## **Advice to decision maker on Wambo Coal Mine South Bates Extension Modification Project**

**IESC 2017-085: Wambo Coal Mine South Bates Extension Modification Project (EPBC 2016/7816; State DA 305-7-2003 Mod 17) – Expansion**

**DRAWDOWN CONTOURS FROM THE
GROUNDWATER ASSESSMENT**

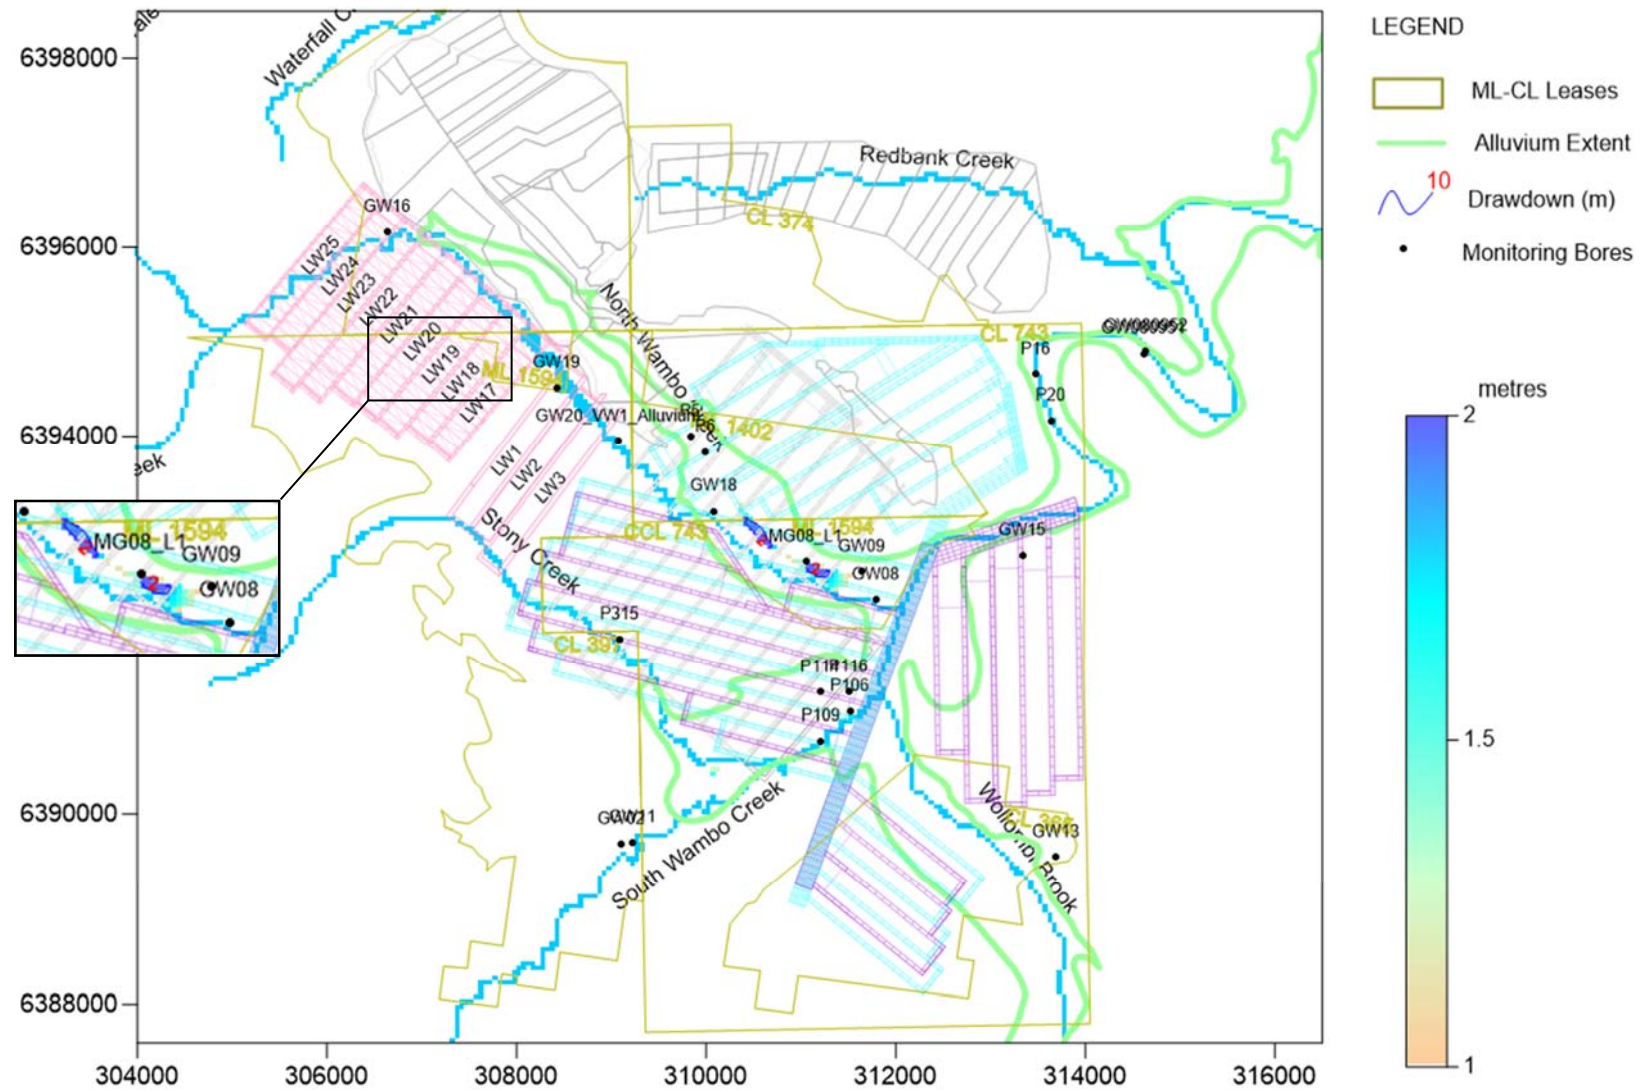
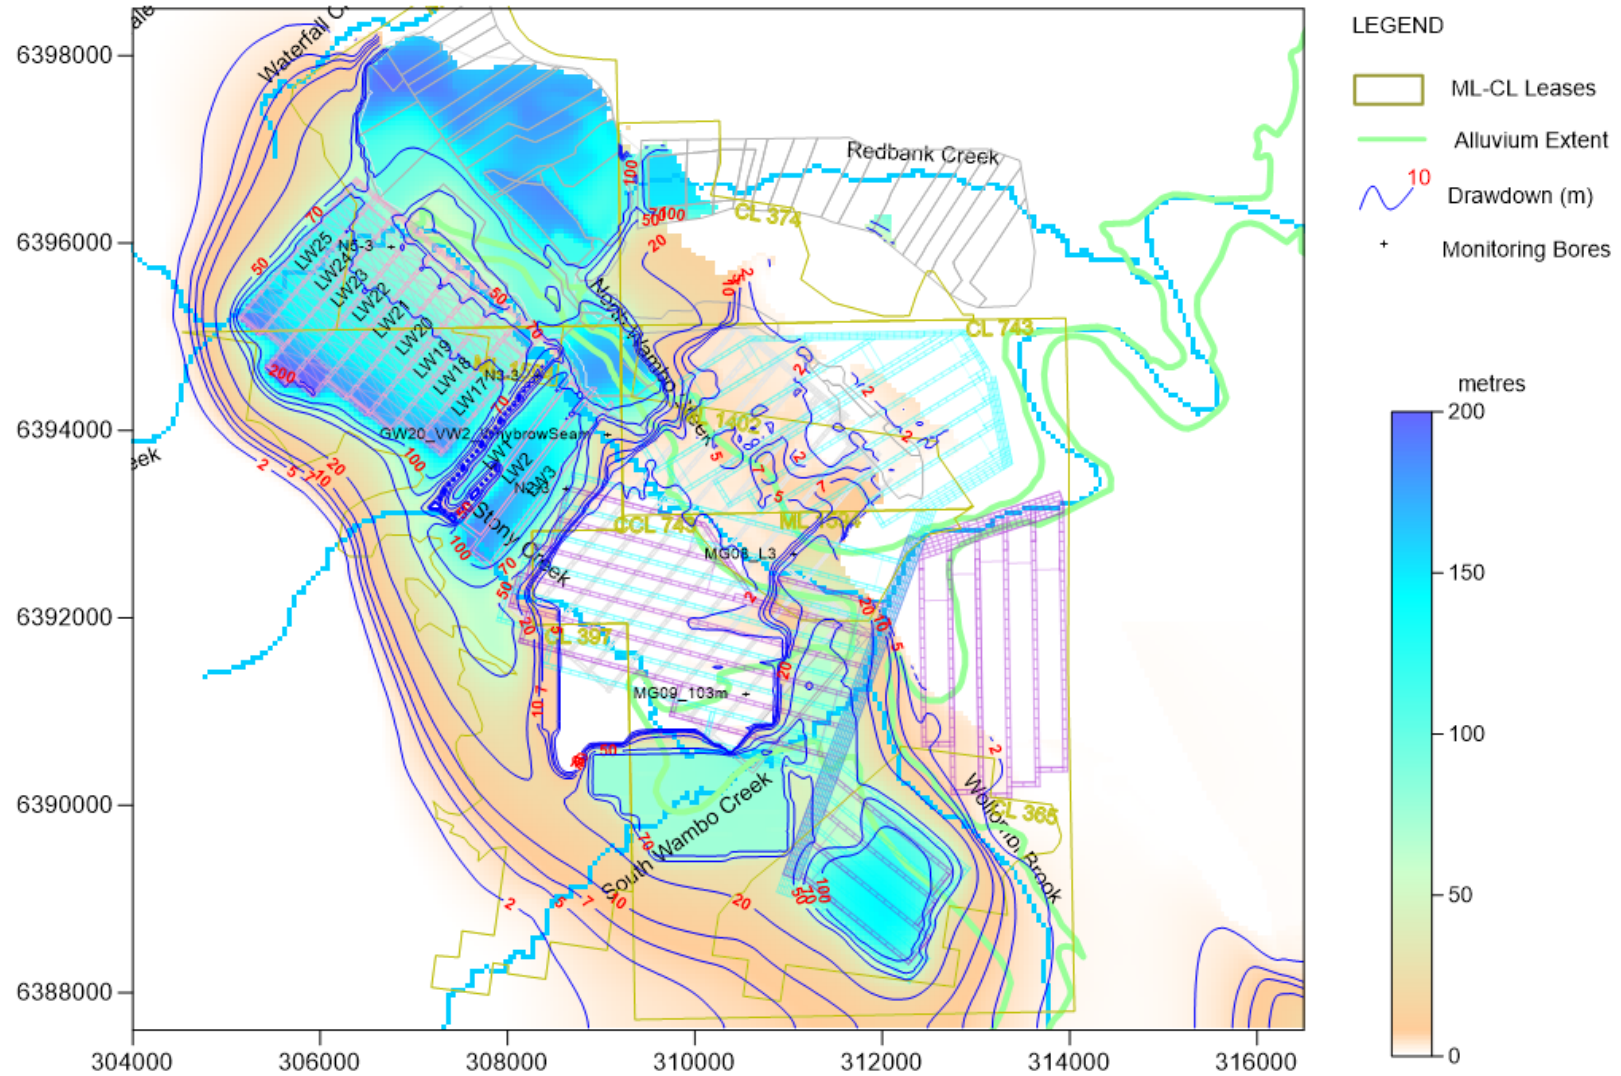
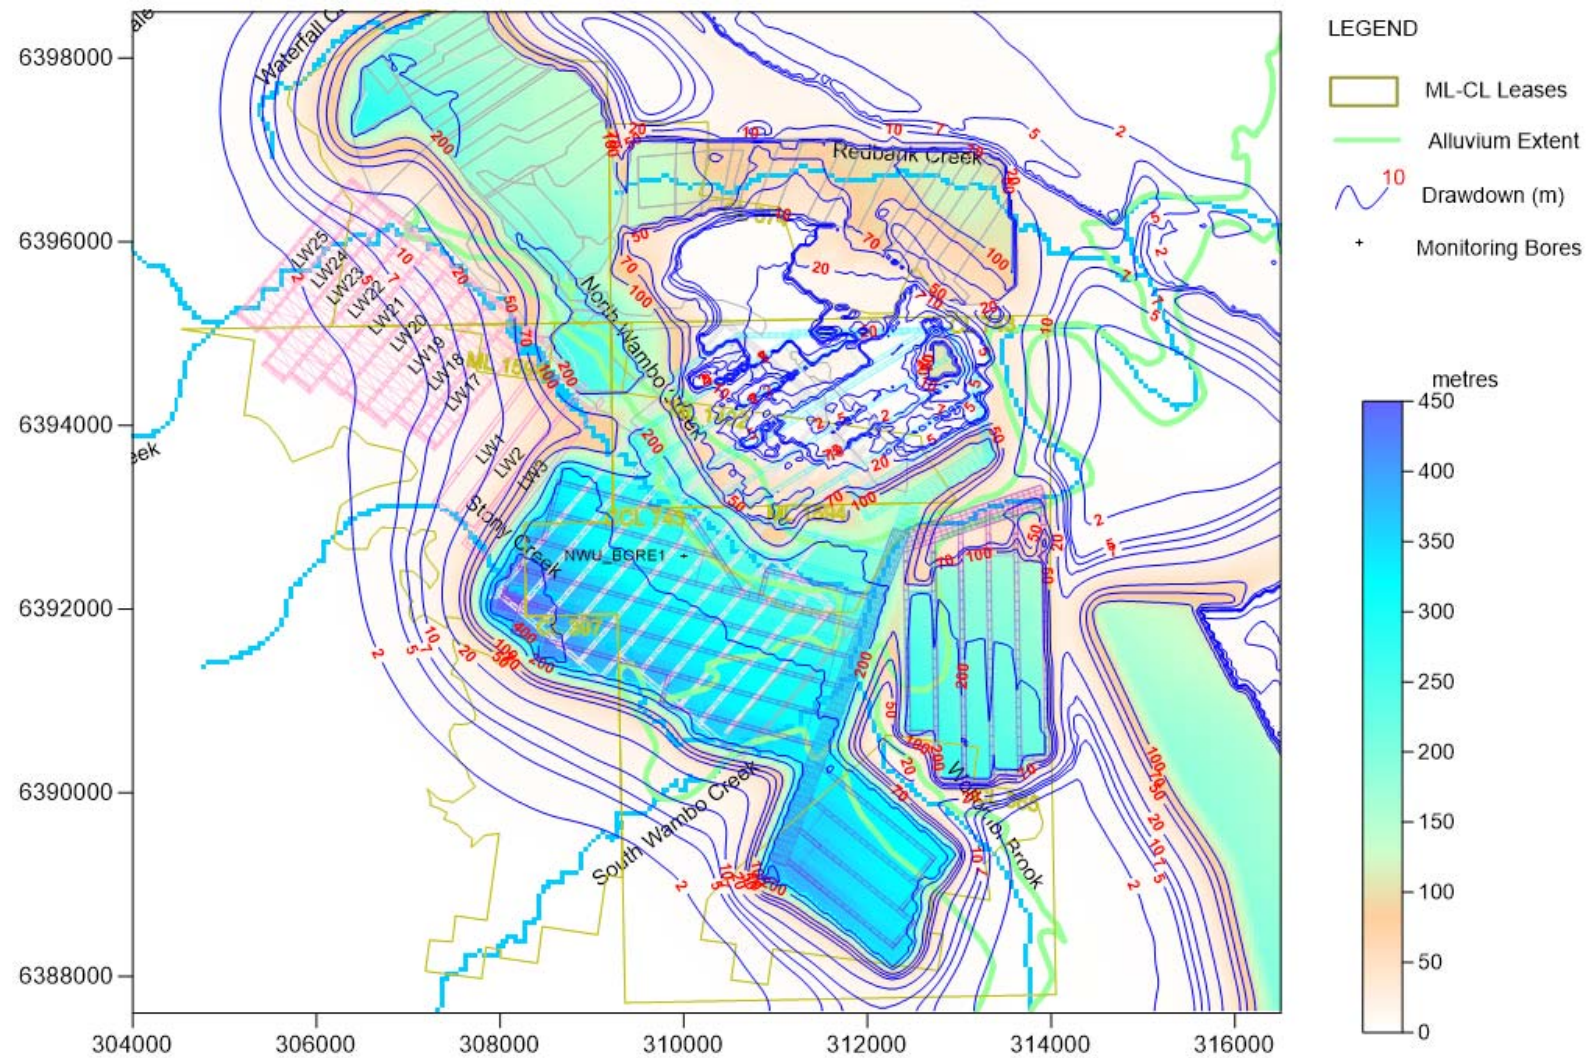
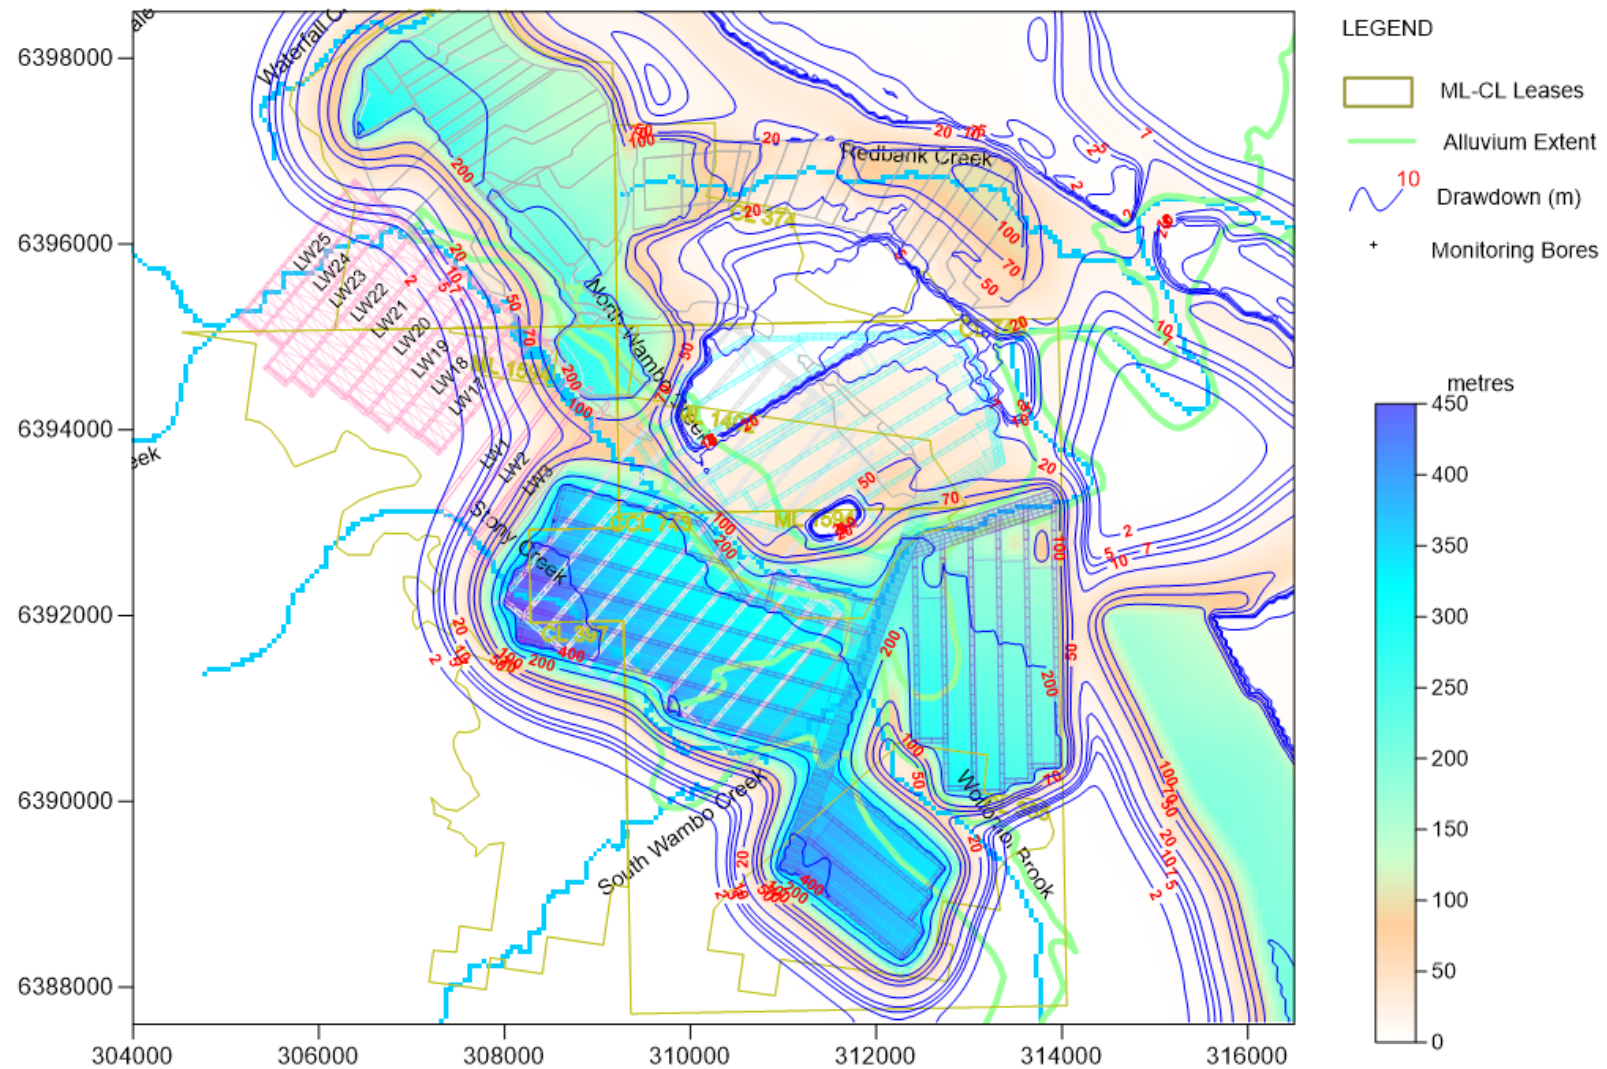
6. The drawdown plots provided in the EA are too small to clearly read the contours, particularly in areas with steep gradients. Clearer and larger versions of these plots should be provided to assist in the assessment of the spatial extent of predicted impacts.

19. Figures depicting cumulative drawdown changes due to the proposed project (EA, App. B, Figures 59-63, pp. 106-108) indicate that drawdown will propagate into the Wollemi National Park. Potential hydrological impacts from cumulative drawdown in the Wollemi National Park should be verified.
